DECISION DELEGATED TO DEVELOPMENT MANAGER

Application No: H18-0945-20 **Applicant:** Mr Dade
Proposal: Erection of garden shed - retrospective
Location: Clear View King John Bank Walpole St Andrew
Terminal Date: 31st December 2020

PROPOSED BLOCK PLAN - 1:500

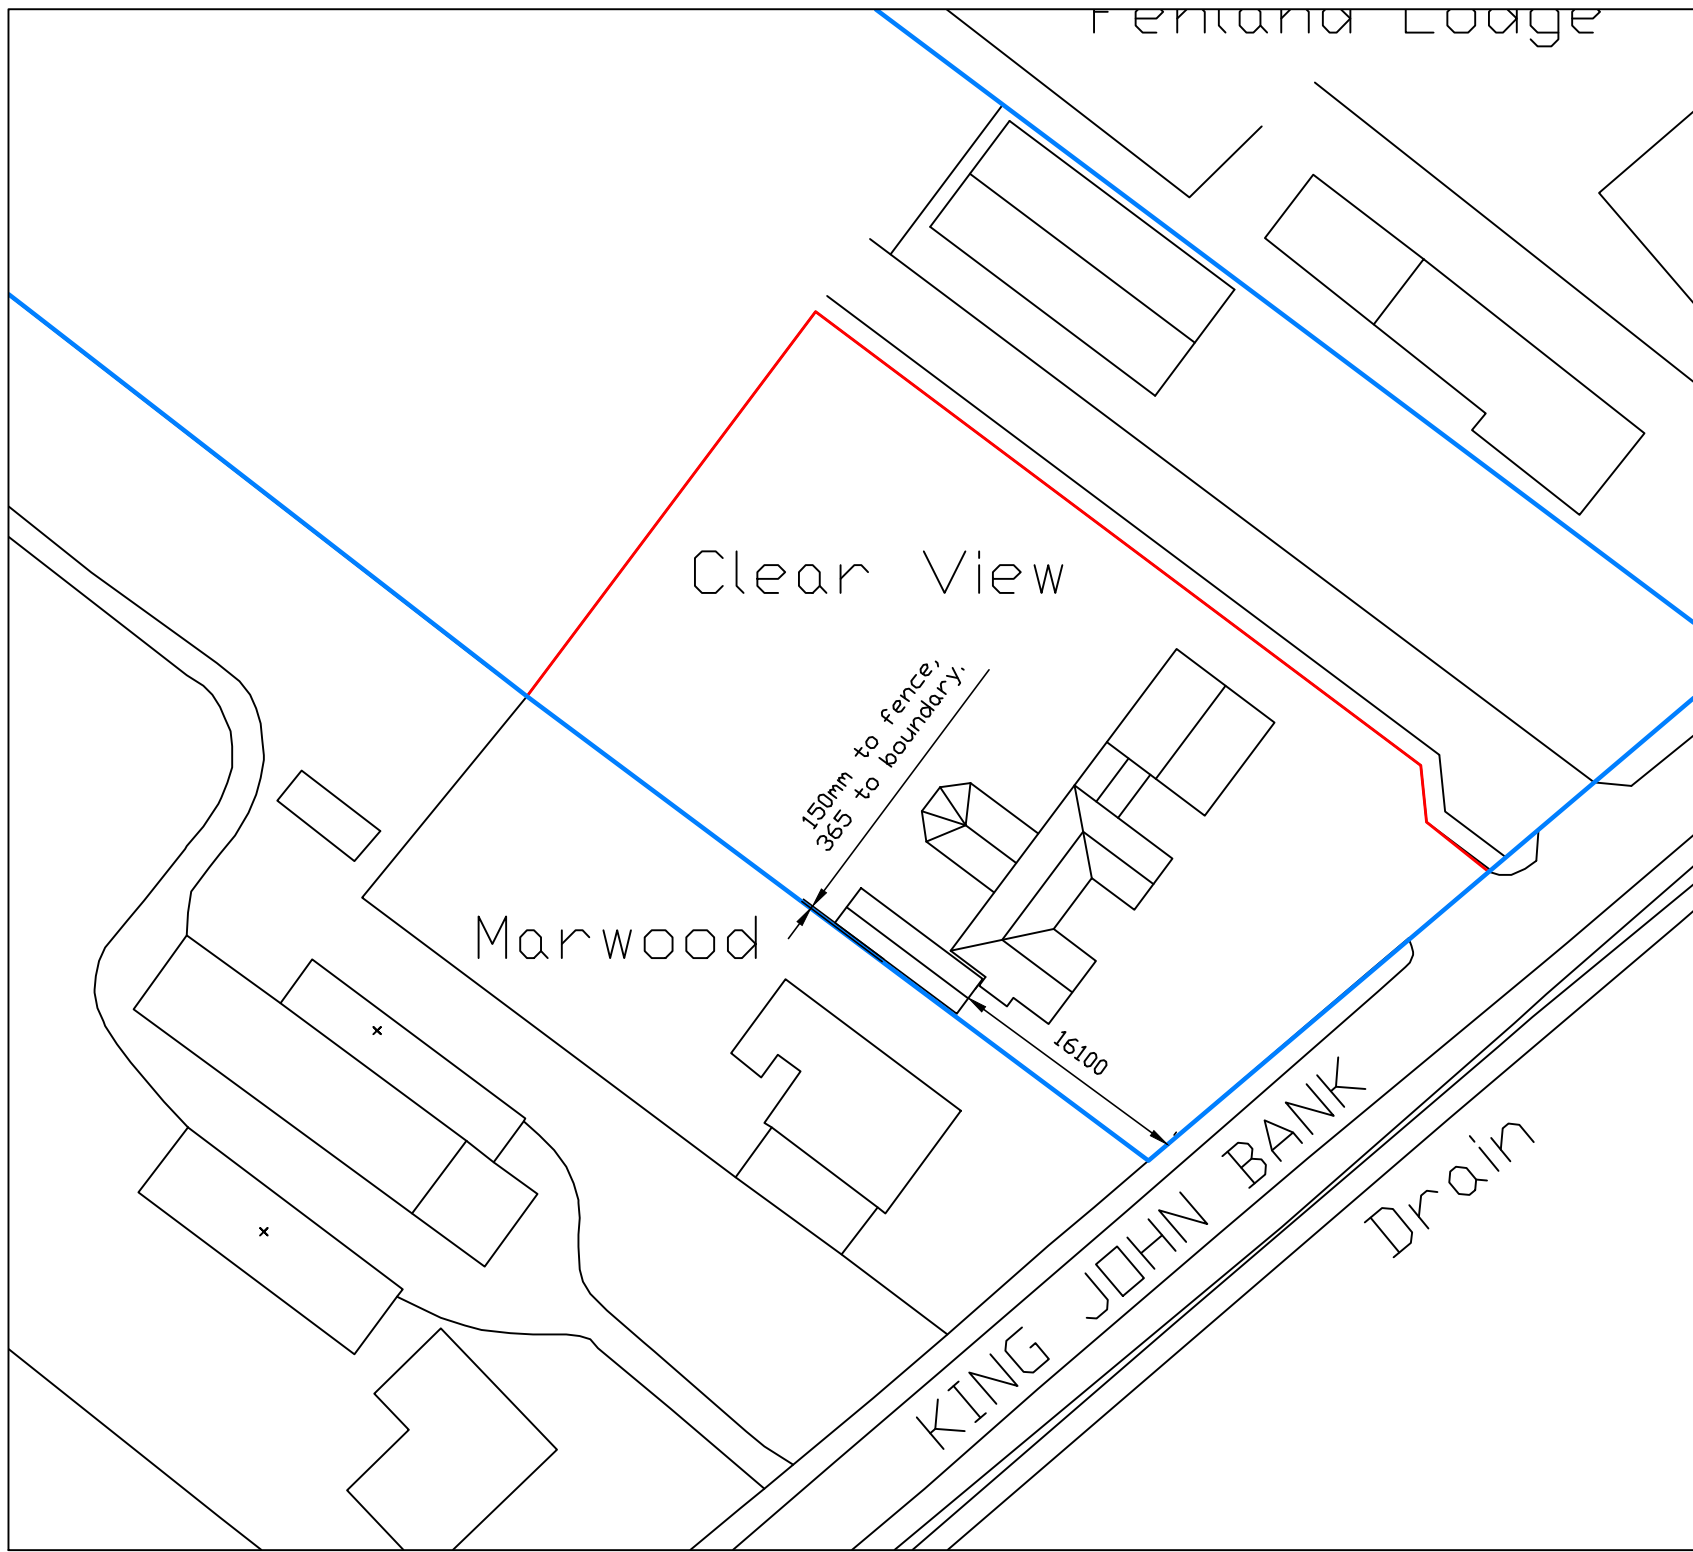
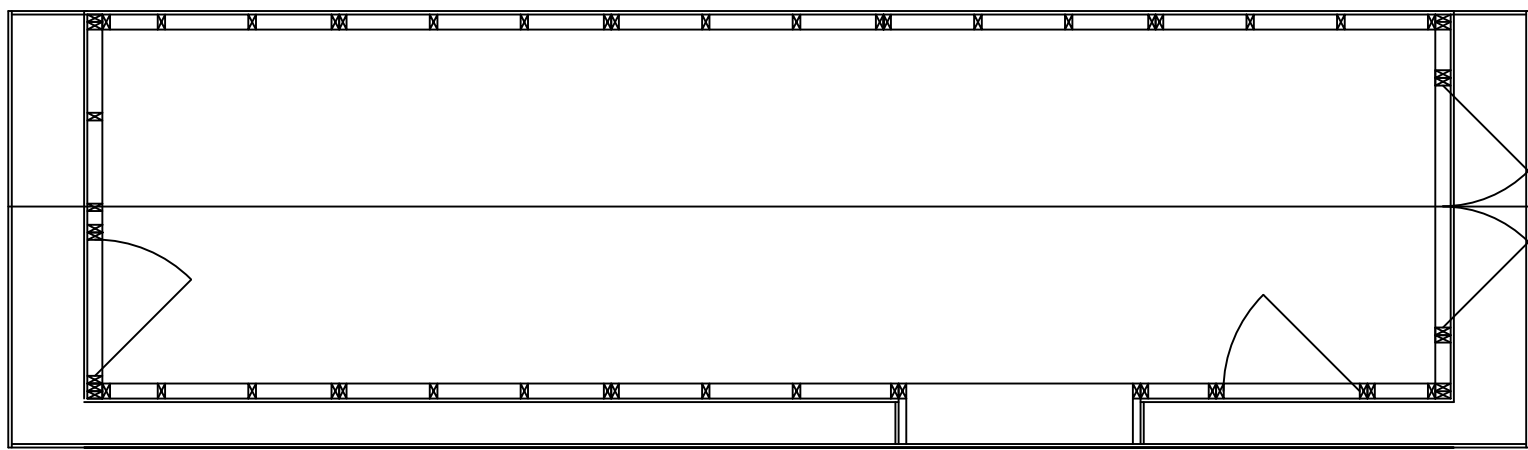
The outbuilding is flanked by the house and the southern-west boundary. It is set back 16.10 metres from the road. Any part of the shed would be 150mm to the fence and 365 mm from the boundary line. Given the scale of the shed at such location, the form of development appears somewhat cramped between the residential property and the fence. However, the scale of the development is commensurate with the built environment in its setting. In addition to the considerations below on residential amenity, on balance there is no sound basis to refuse the development in terms of design, layout and impact upon character of the local area.

JOB NUMBER 2109	Sheet
Date 19/10/2020	01B
Scale AS NOTED @ A1

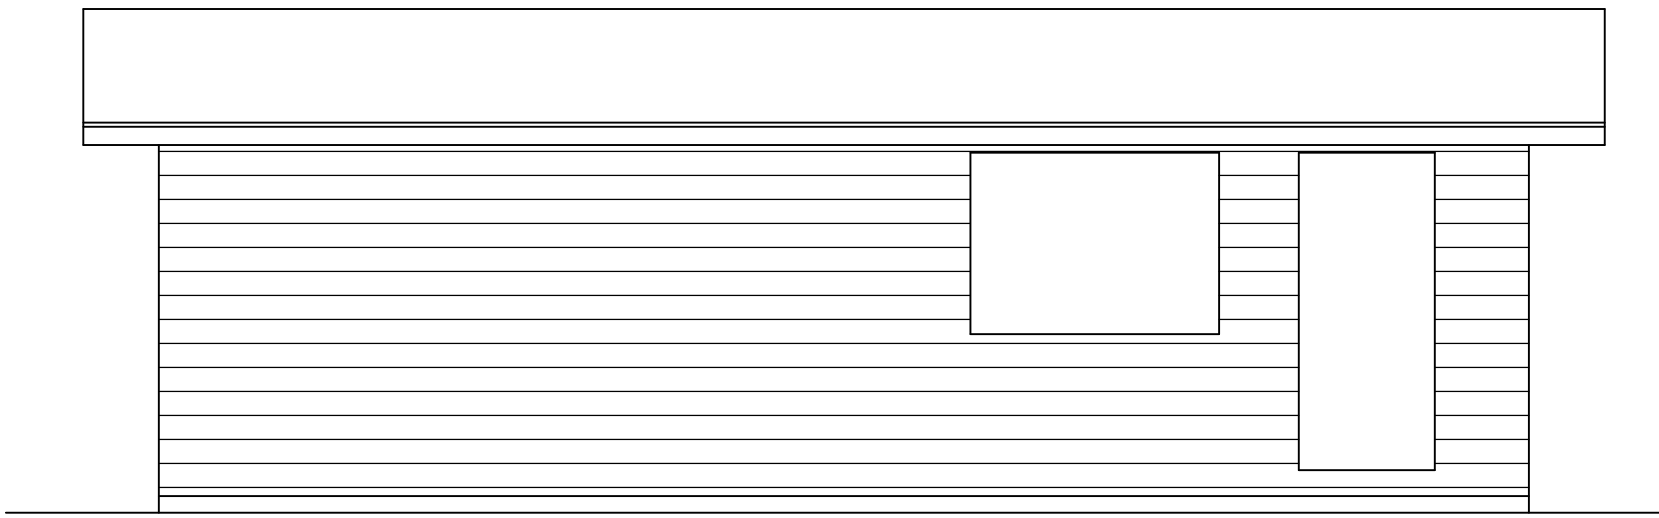
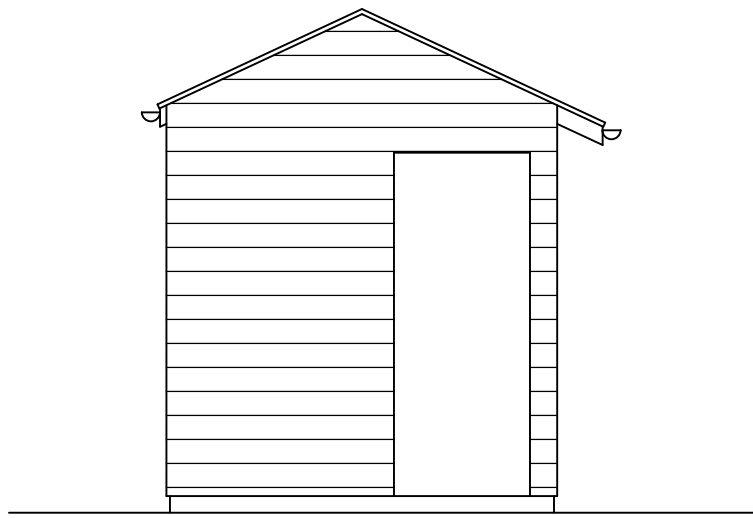
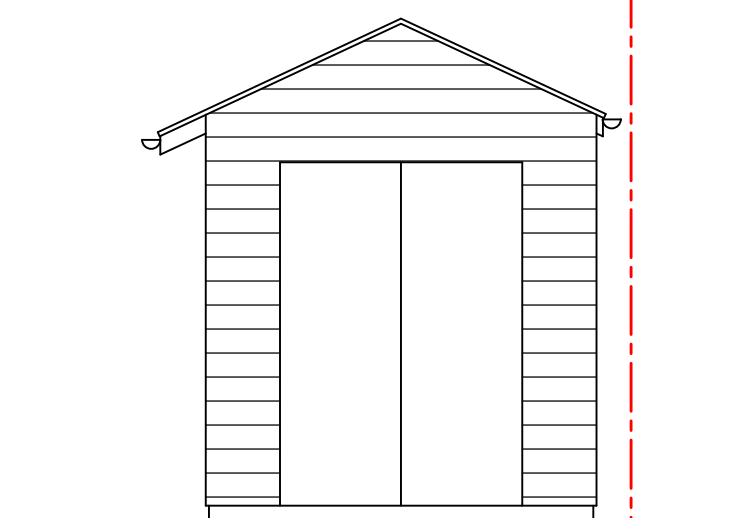
The roof overhangs on the front, rear and one of the sides elevations. It currently overhangs surpassing the boundary fence although the applicant has confirmed that the protruding edge will be cut to prevent any encroachment onto the adjoining site of Marwood. In doing so, no legal conflict would occur between the two parties involved.

By the time of the case officer's site inspection, no rainwater goods were incorporated to the shed. Any strategy of surface water management is required in order to increase the risk of flooding in the vicinity of the development.

In addition to the cutting of the roof overhang onto Marwood, guttering is proposed without being above the boundary fence on the revised drawings to determine should planning permission be granted. The surface runoff from the rooftop will run into the downpipes to the underground drainage leading to soakaways.
